Our ref: DOC21/26870
Senders ref: SSD 10425

Response to Submissions – Tallawong Station Precinct South – Stage 2 Detailed Design Modification Application 1 (SSD 10425)

FIGURE D5 FLOOD LEVEL DIFFERENCE – 1% AEP

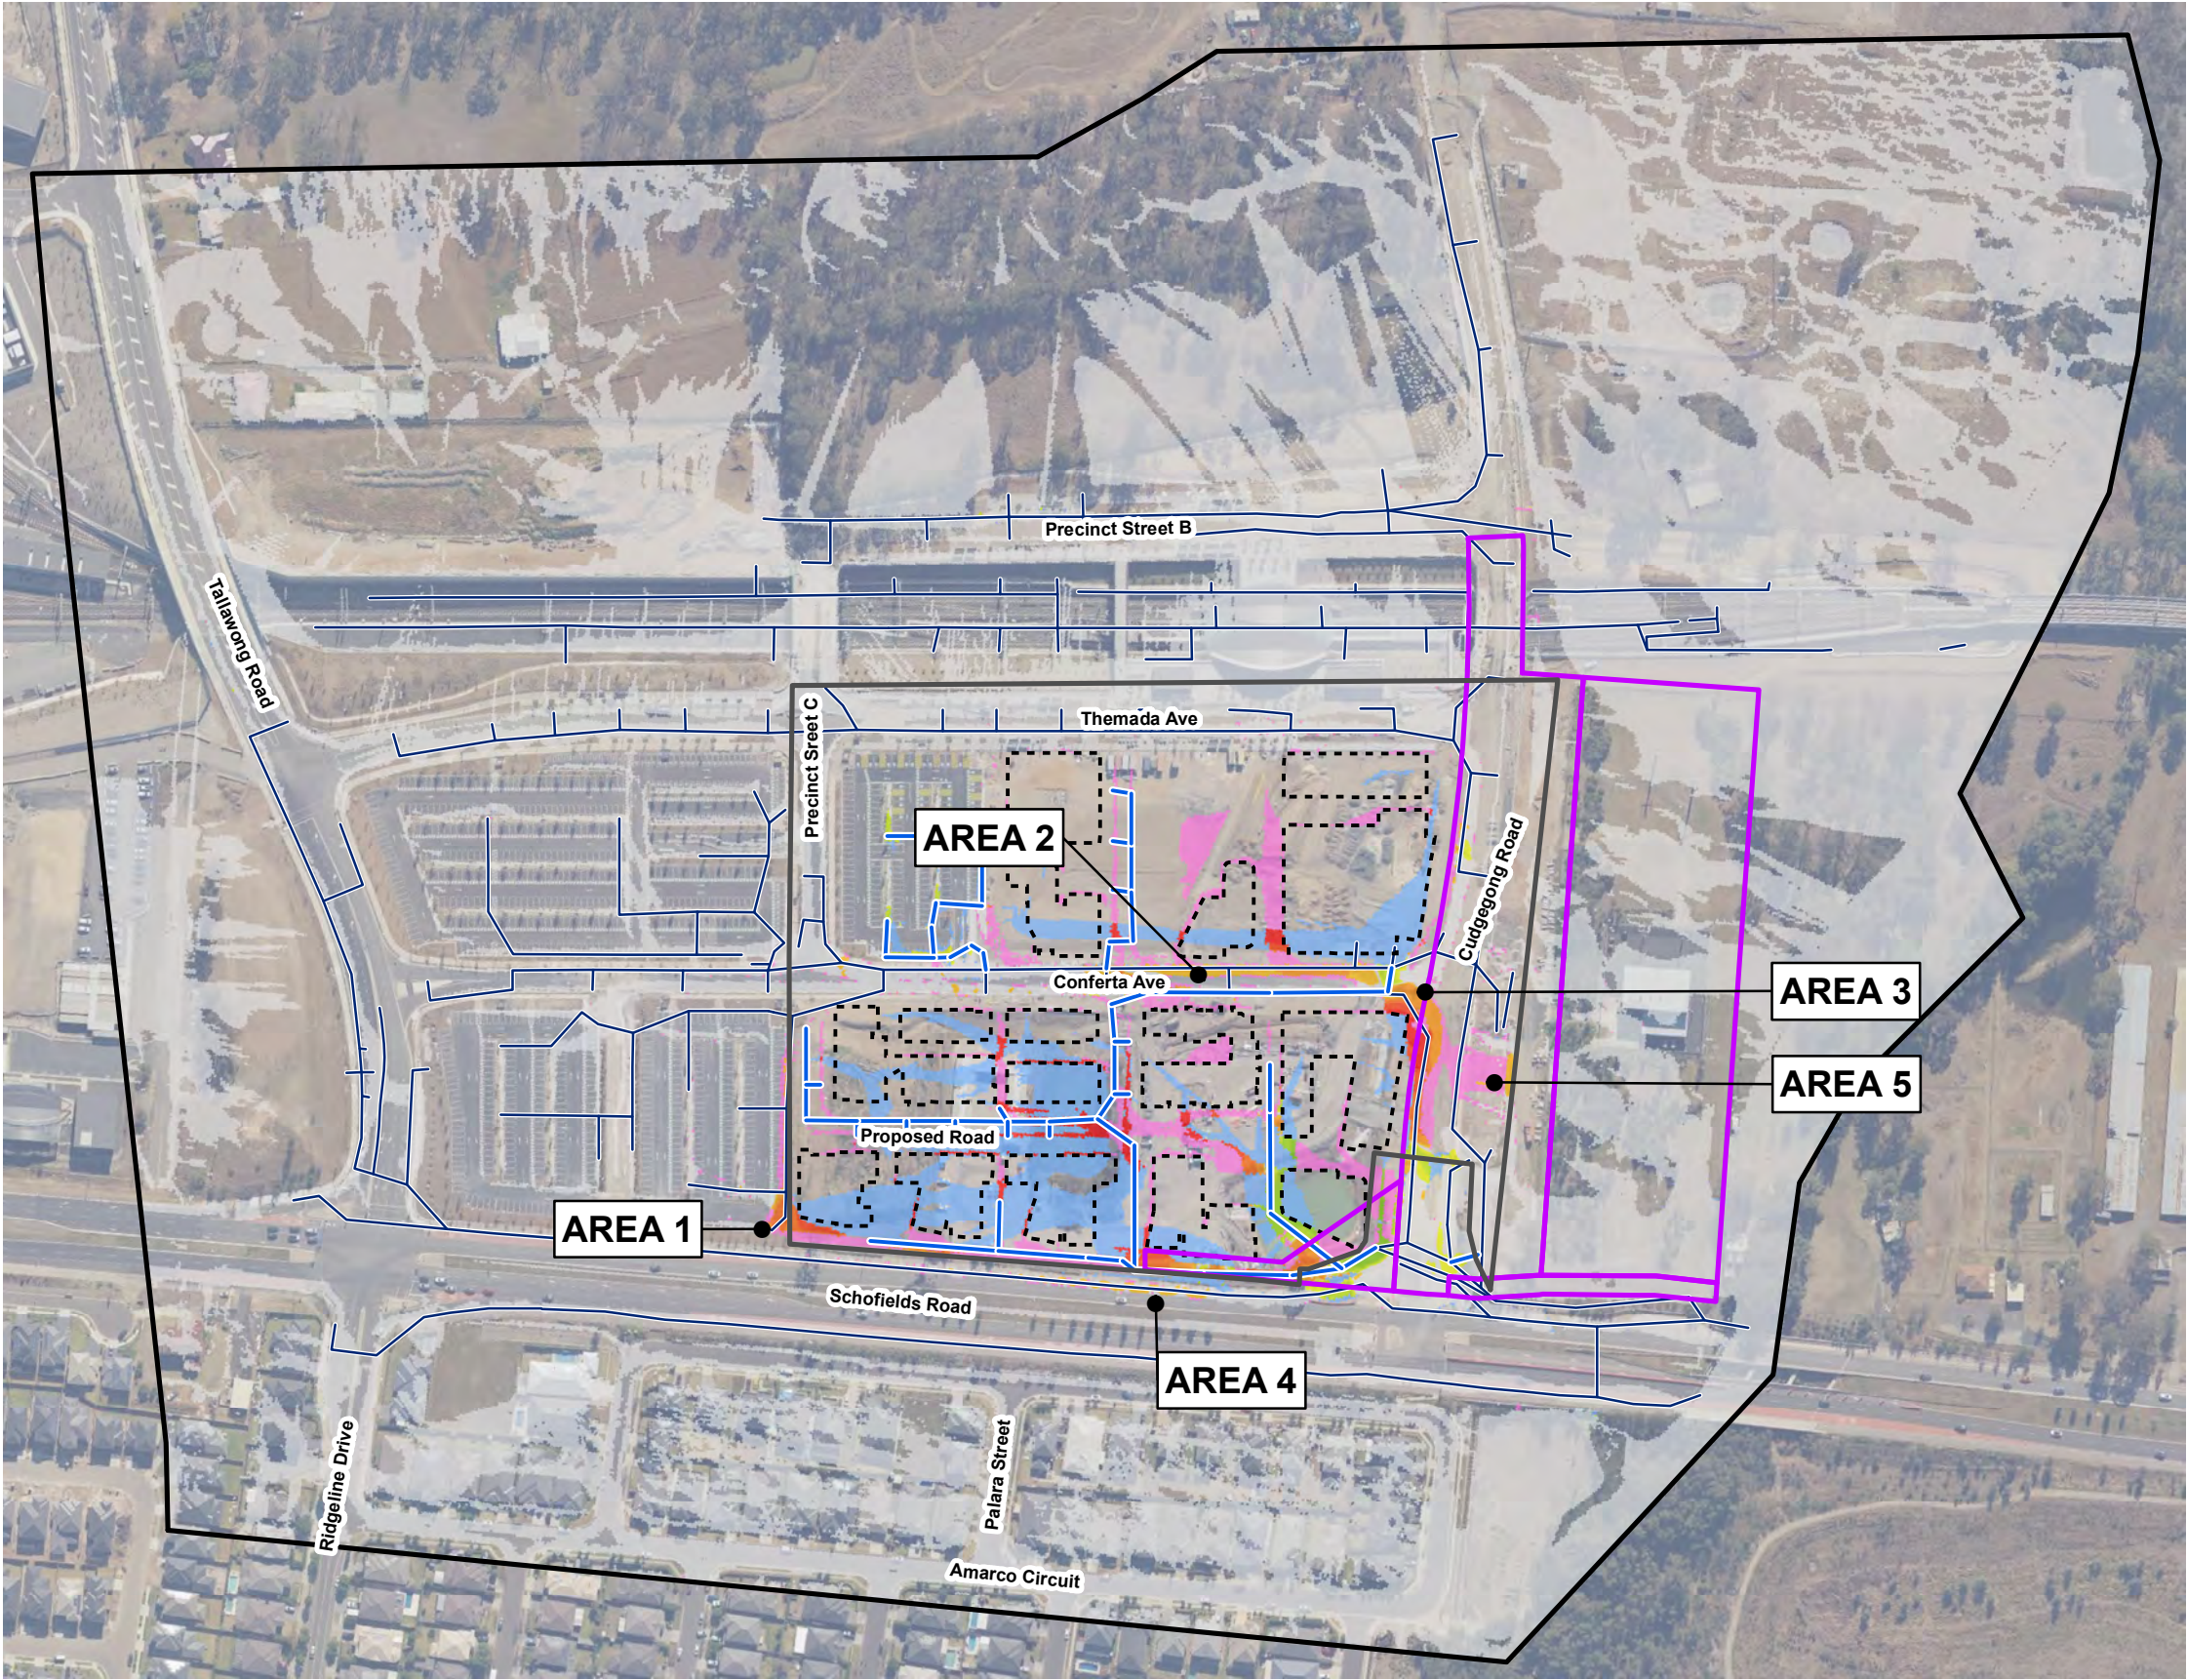
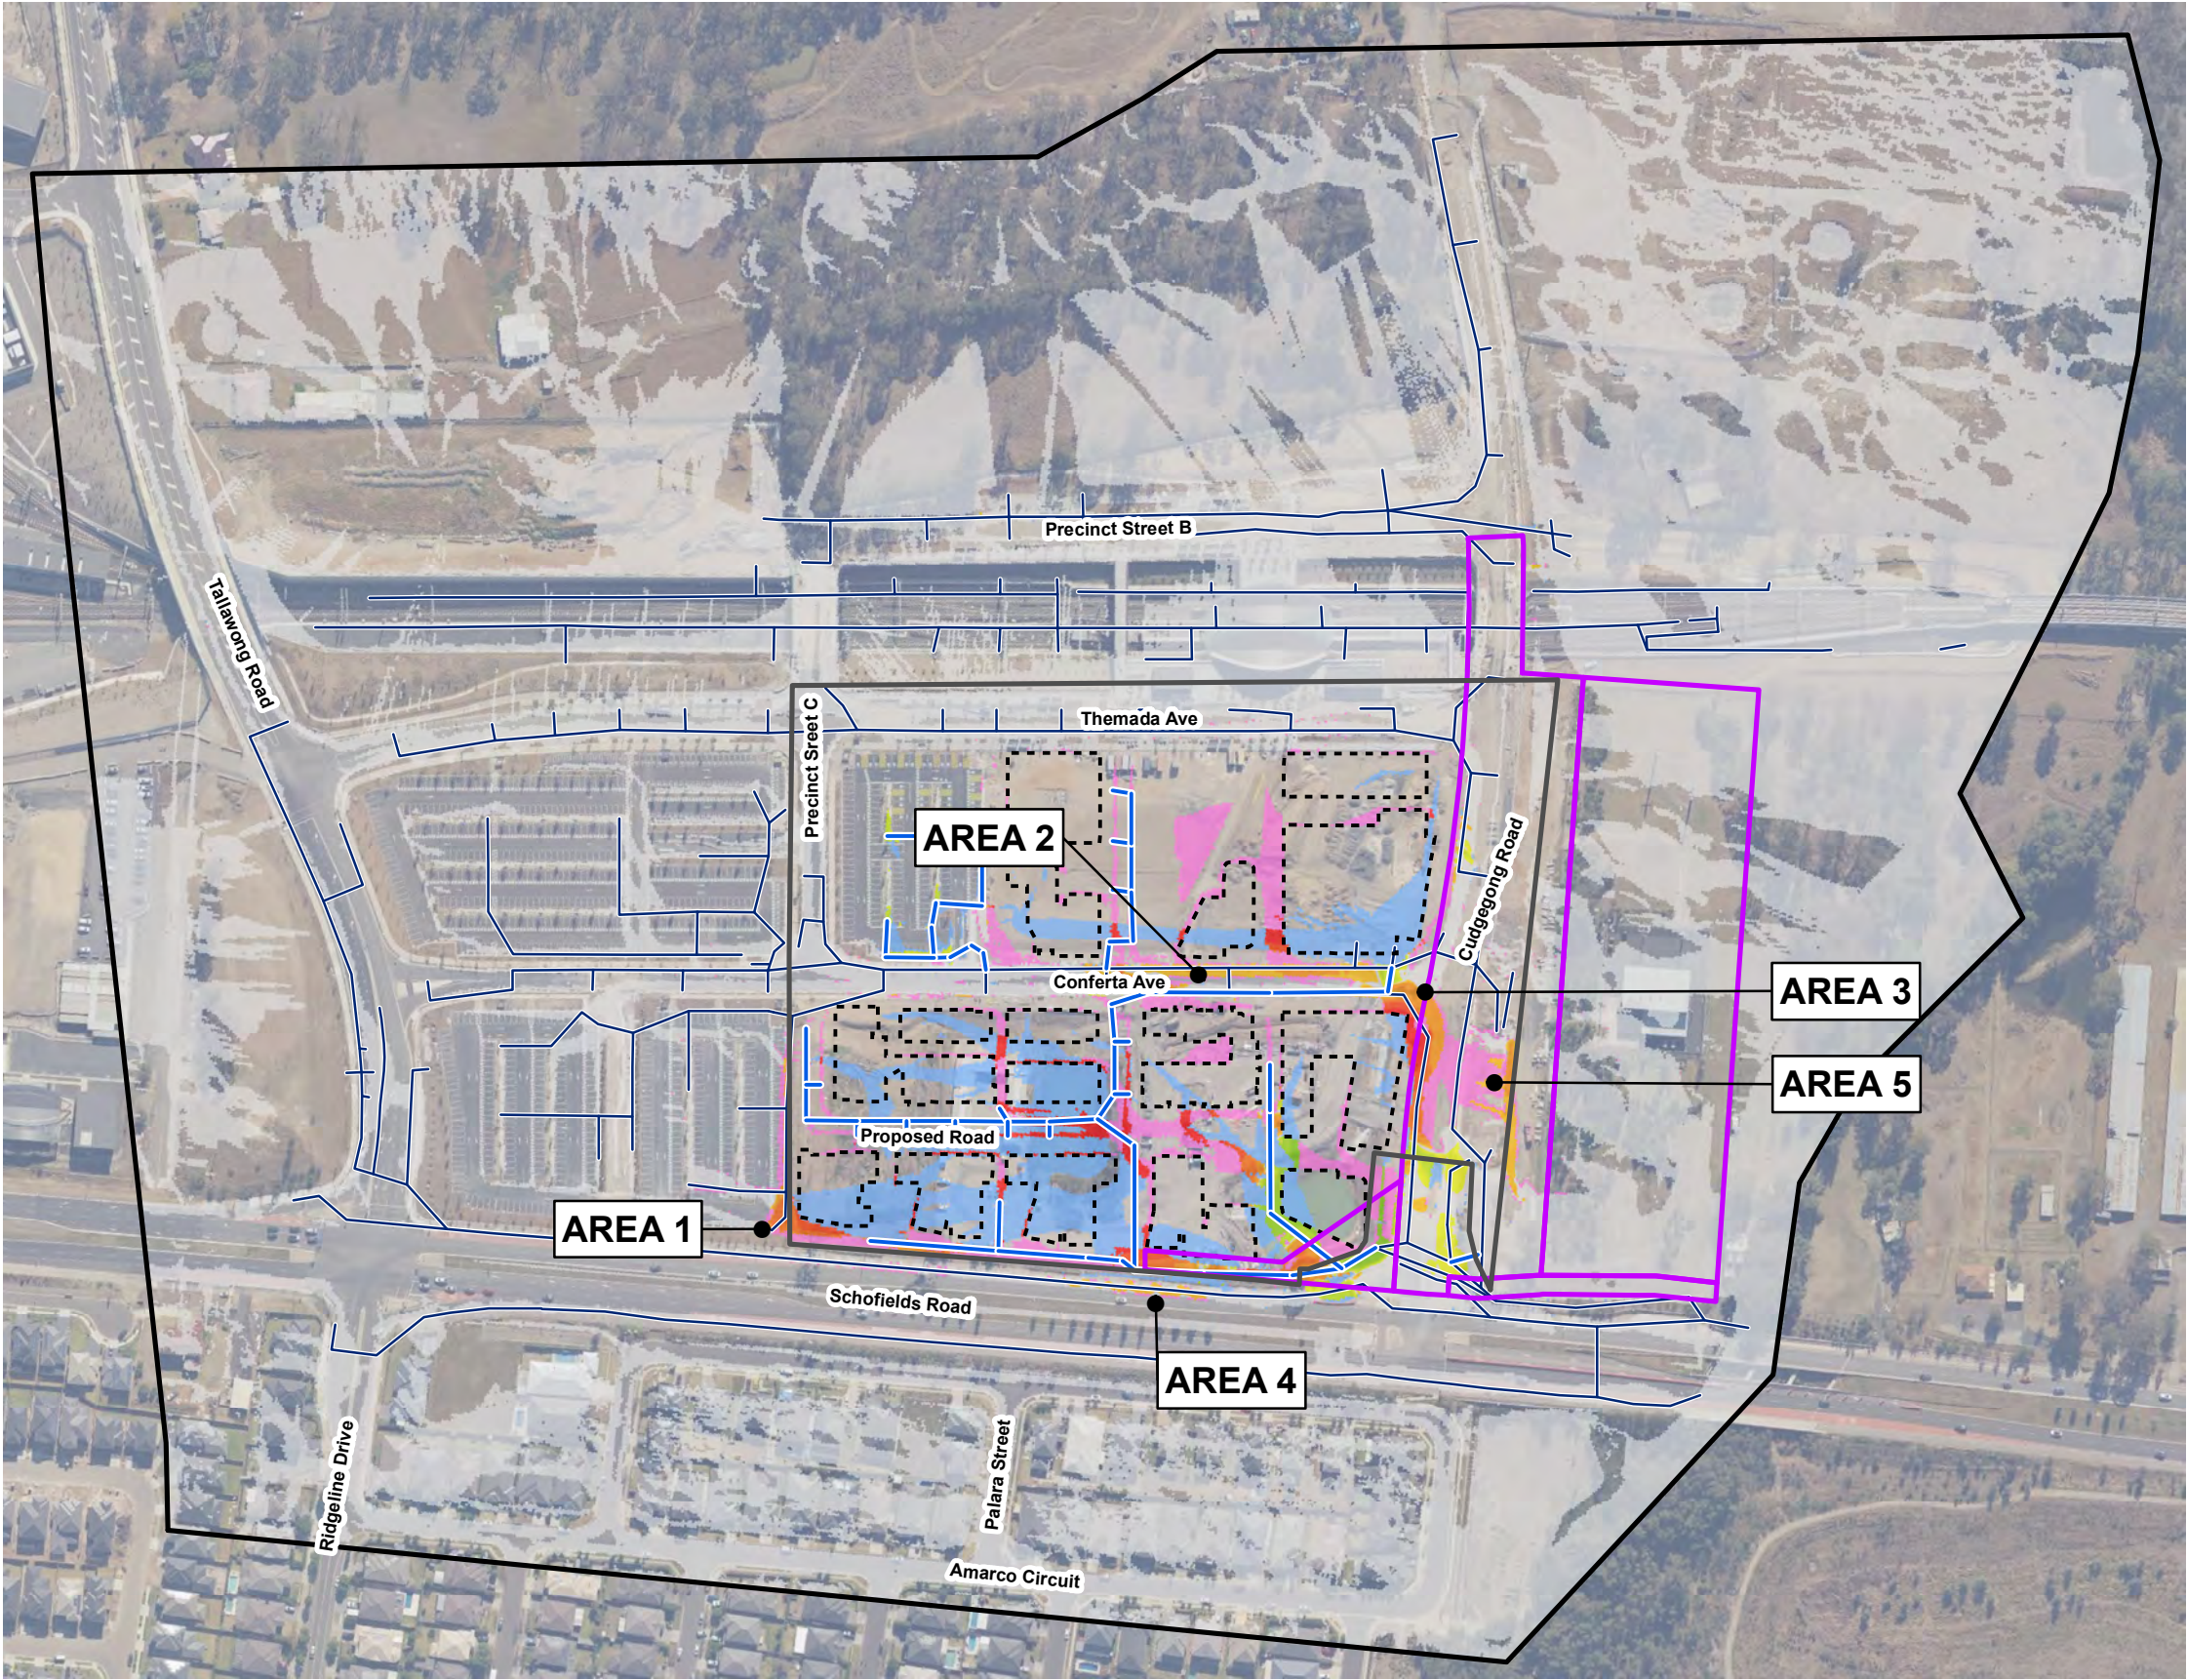
- The flood level difference maps need careful review as they show some discrepancies particularly at the southern corner of Cudgegong Road. The difference maps show reduction instead of increase in levels at this area for all flood events.
